REF: 22/01144/F

Location: OS Parcel 5700 South West Of Grange Farm

Holding objection

25 May 2022

Drawing Name:
Proposed Plan & Elevations

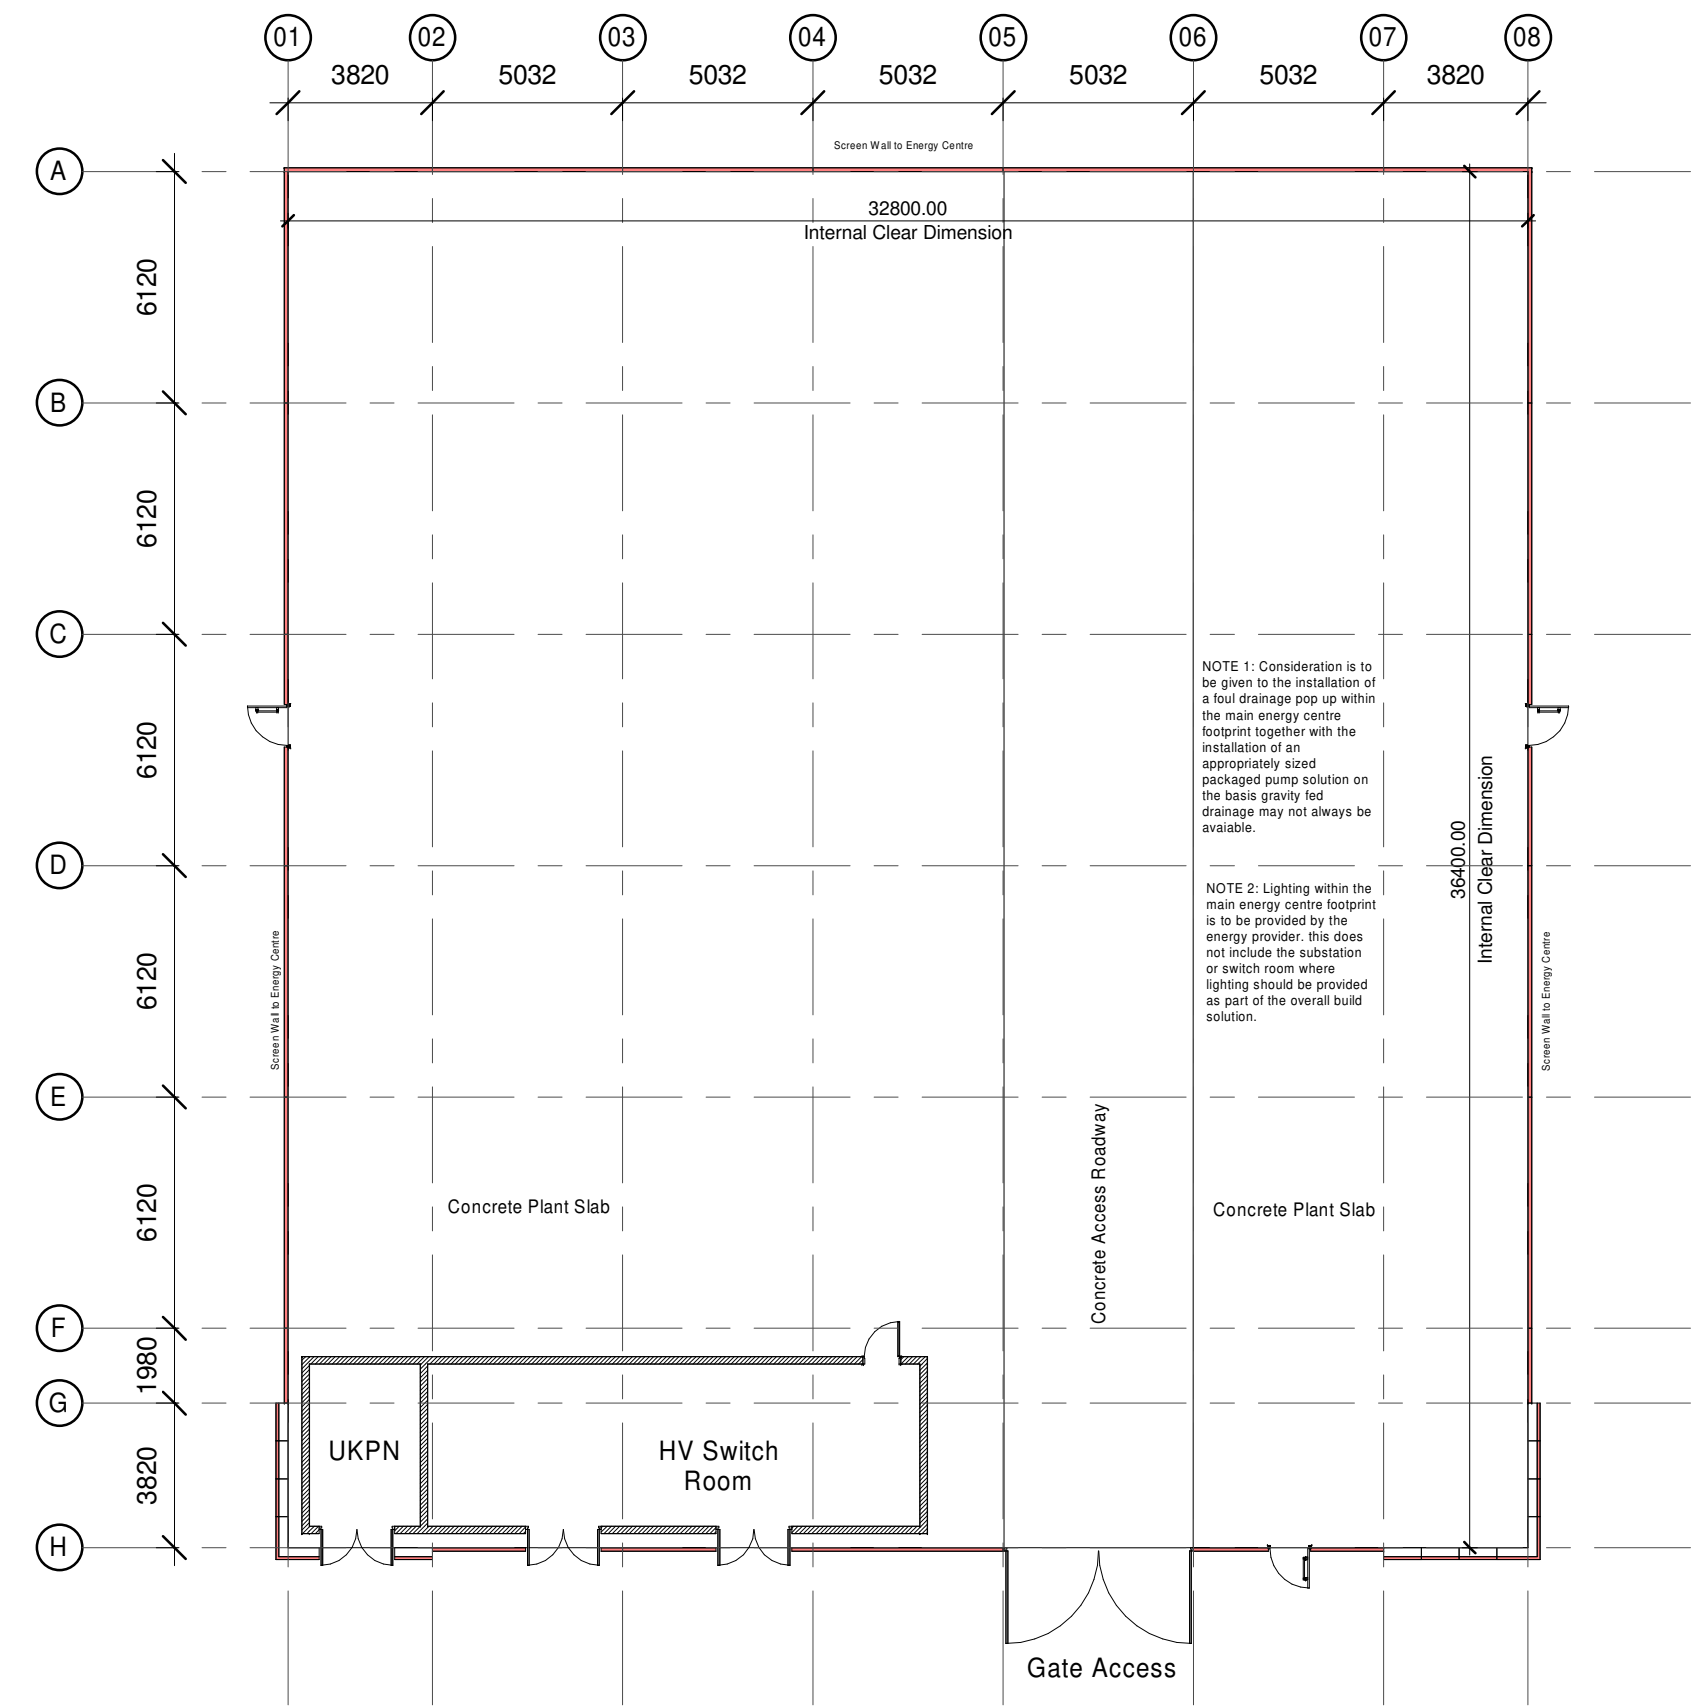
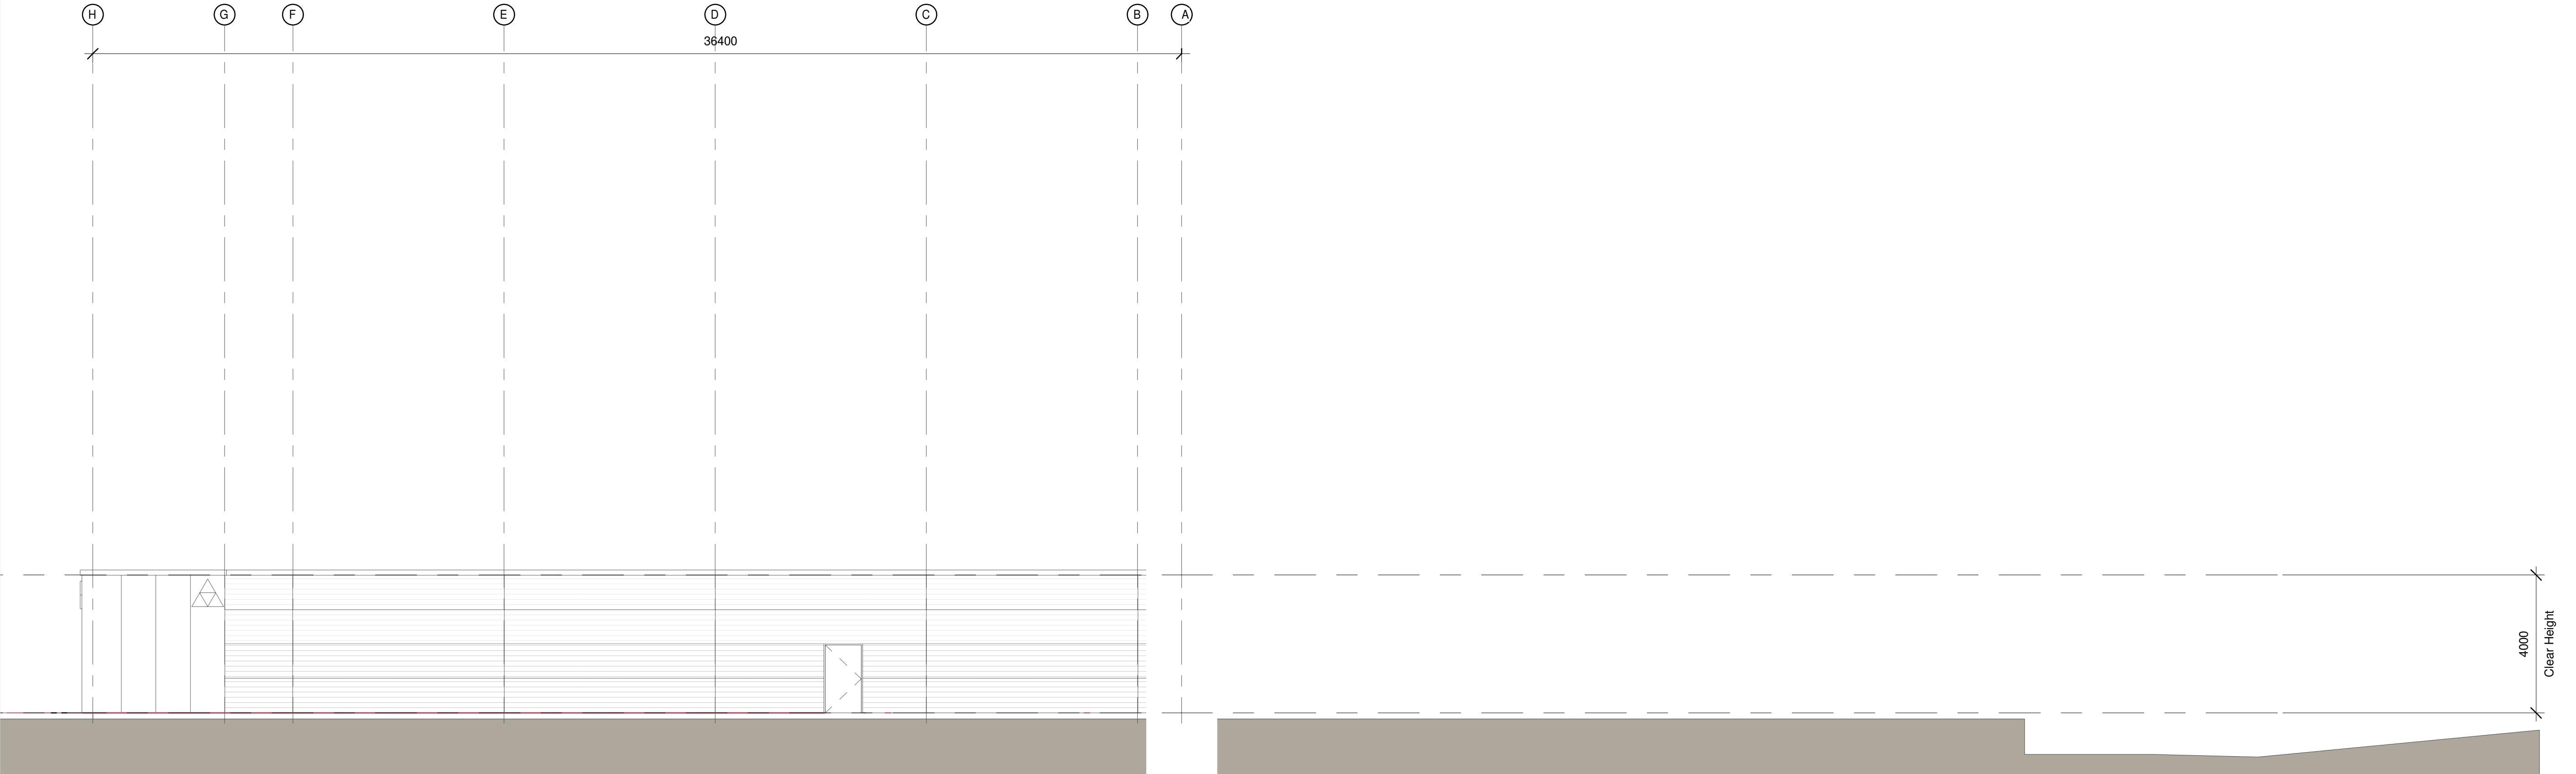
- The energy centre is vulnerable, located outside the secure building line in an area where surveillance over it may be restricted by landscaping and planting. I recommend this is relocated within the secure boundary of the building, or where it is covered by surveillance from the gatehouse building.
